DEVELOPMENT REVIEW BOARD
TRANSPORTATION DEVELOPMENT

DRB Project Number: 1011533
Baldonado Property

SUBJECT: Sketch Plat

SKETCH PLAT OF
Tract 196A-2-B-3-A-1
M.R.G.C.D. Map 35

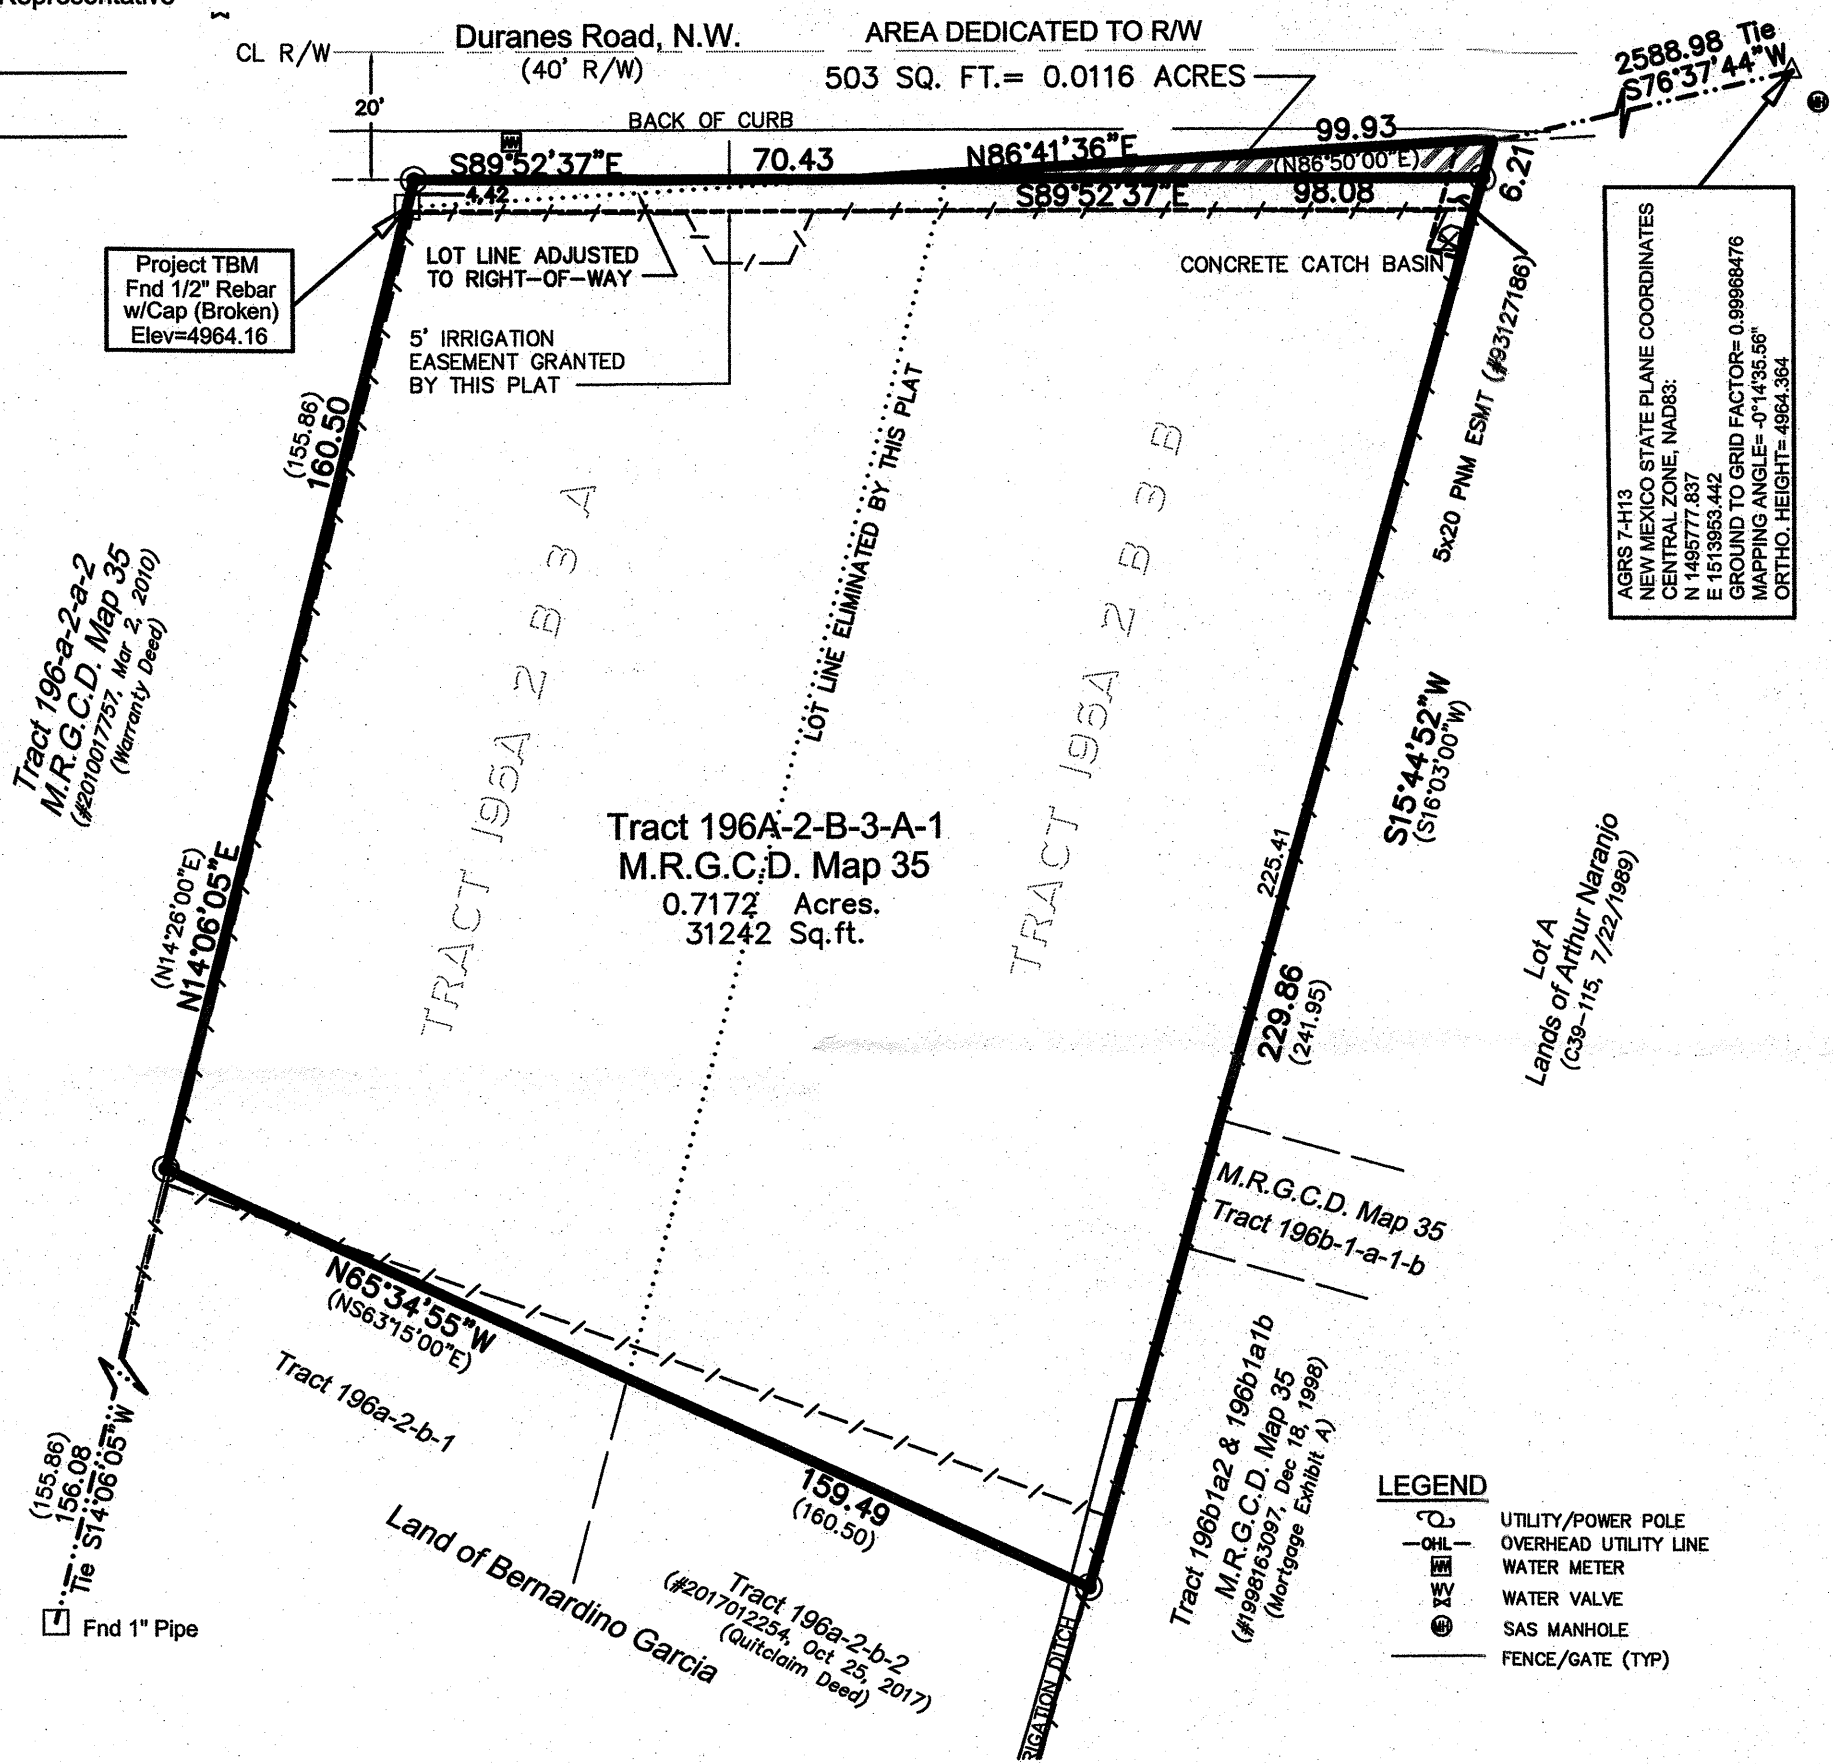
1. The proposed area is designed below current City of Albuquerque design criteria. A number of variances (width of pavement, lack of sidewalk) will be required for this request. Justification must be provided.
